# Planning Inspectorate

Our Ref: EN020026

Date: 5 September 2025

## **Application by National Grid Electricity Transmission for an Order Granting Development Consent for the Sea Link Project**

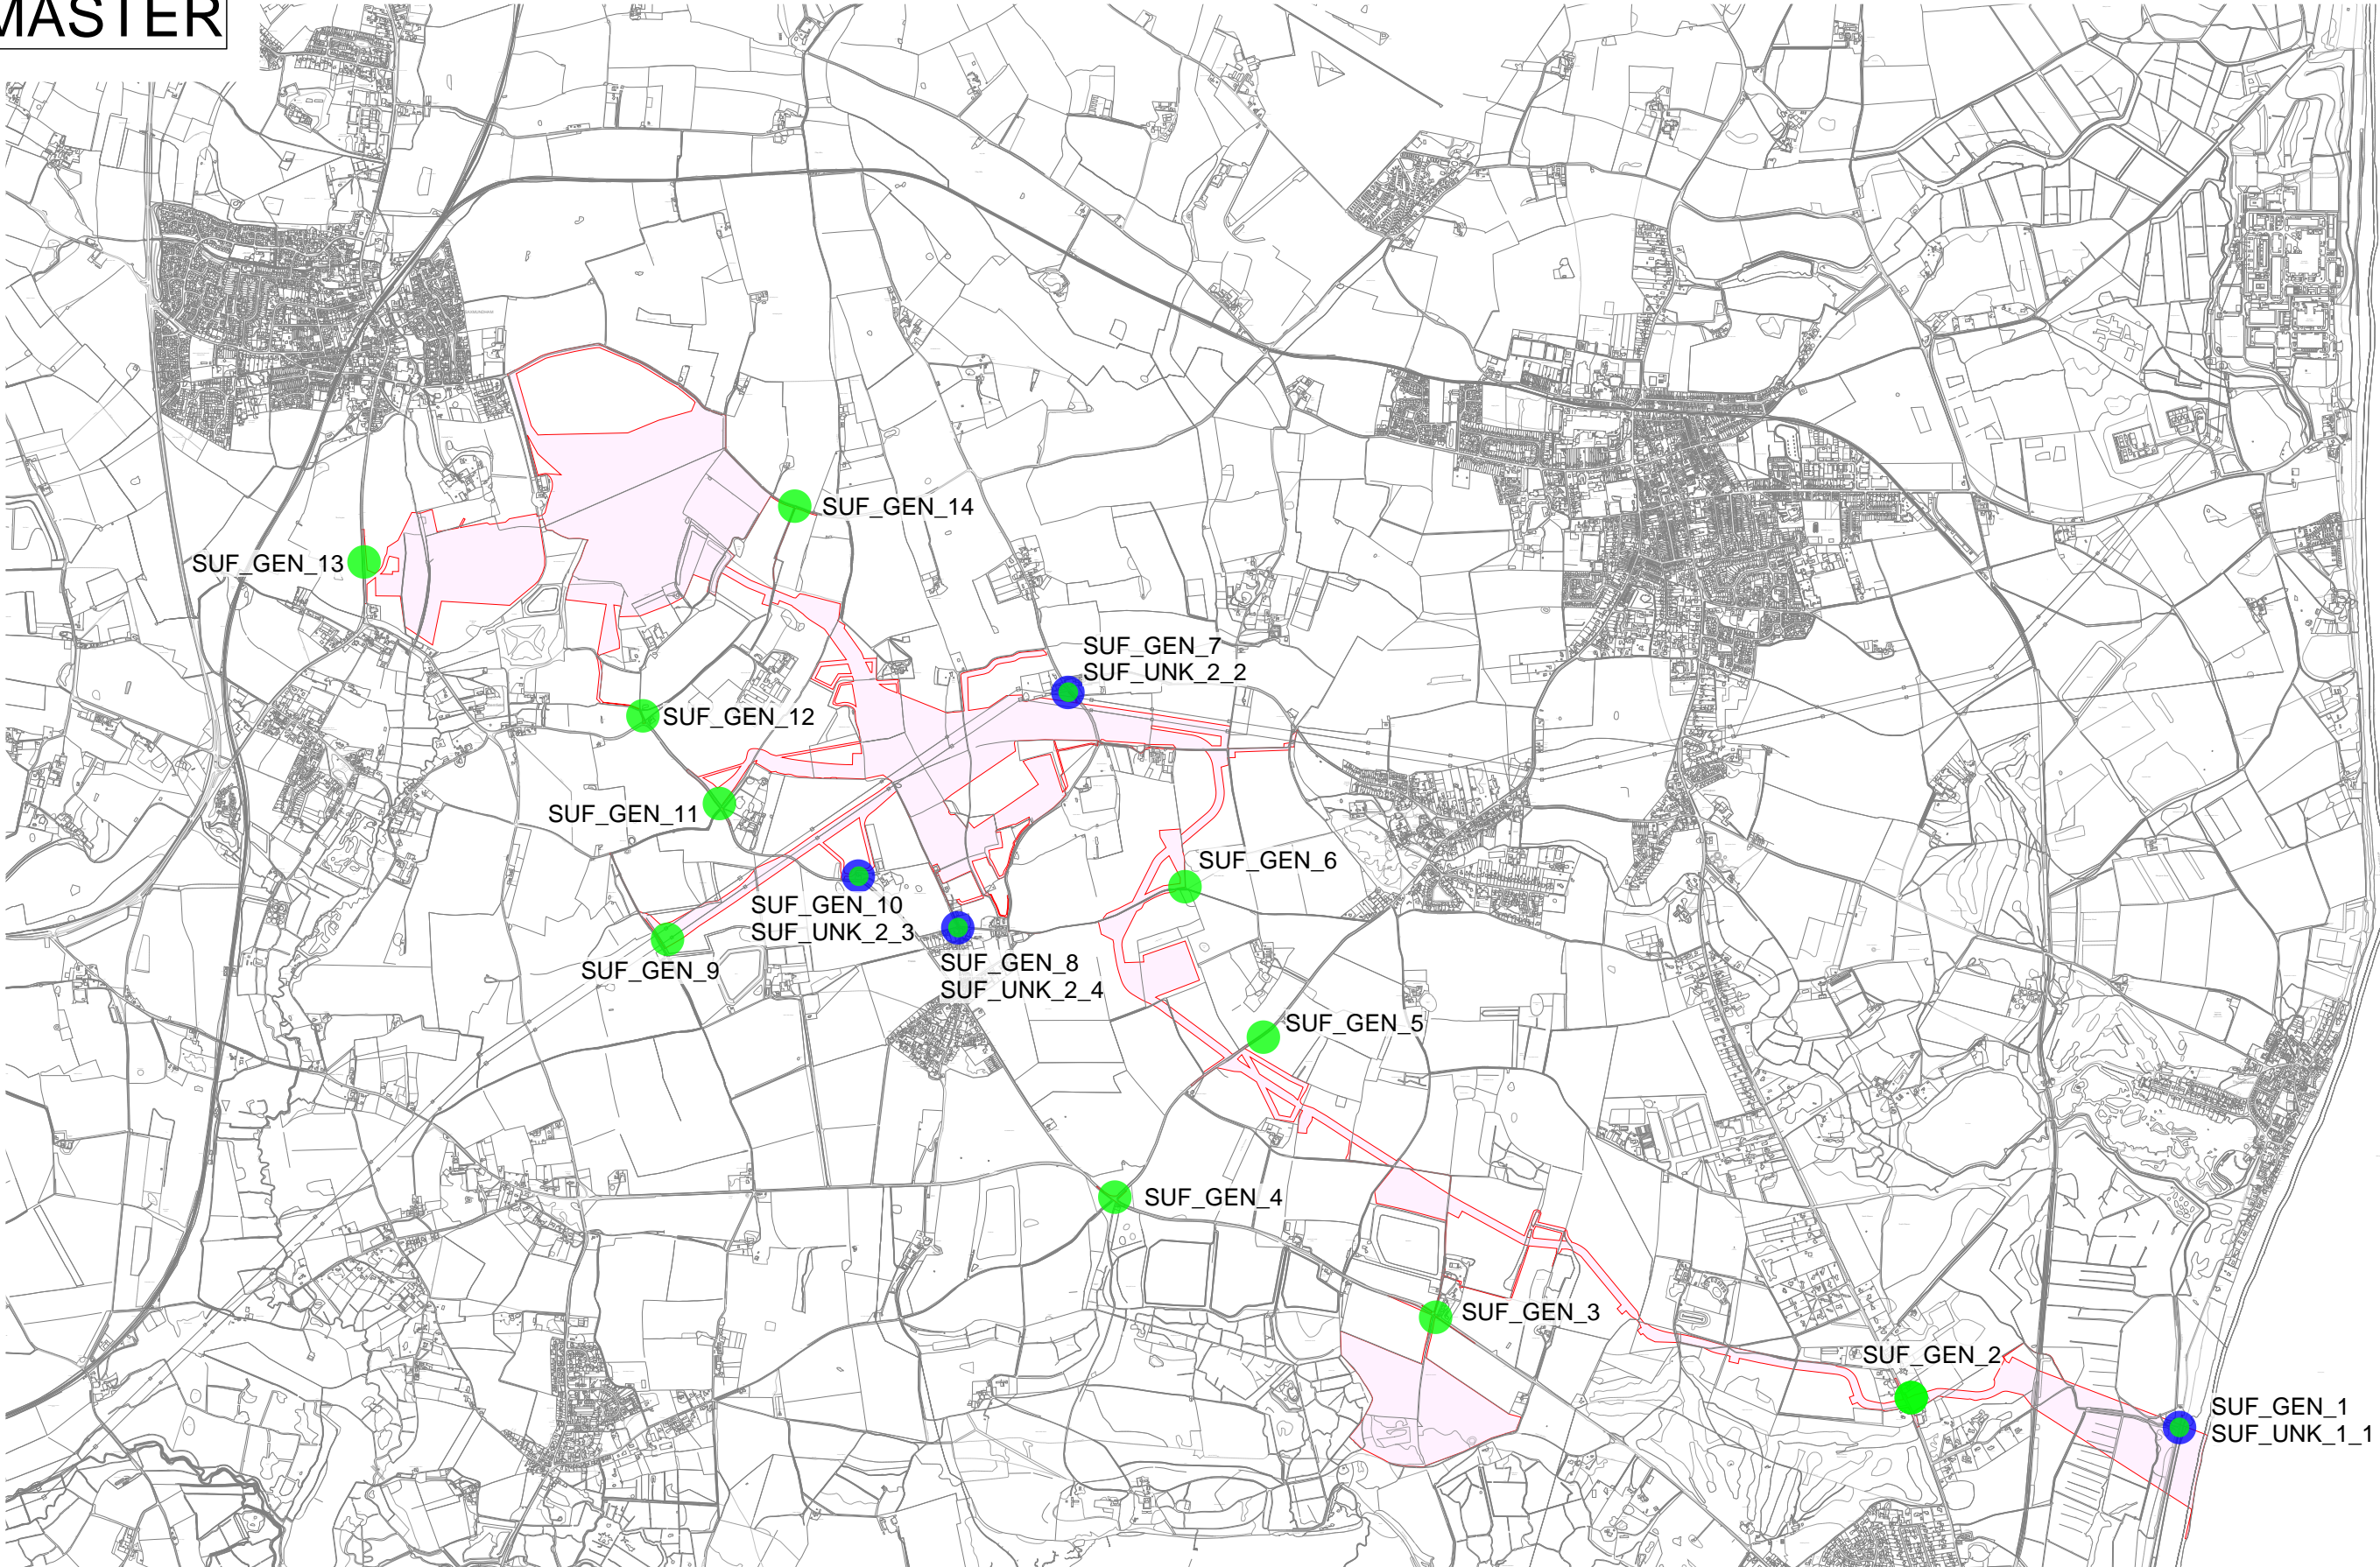
Your 1 September 2025 submission [AS-084] stated that the locations used for the site notices in Suffolk and Kent were shown on attached plans. No plans were attached to or included within the applicant's submission. Please provide the plans referred to.
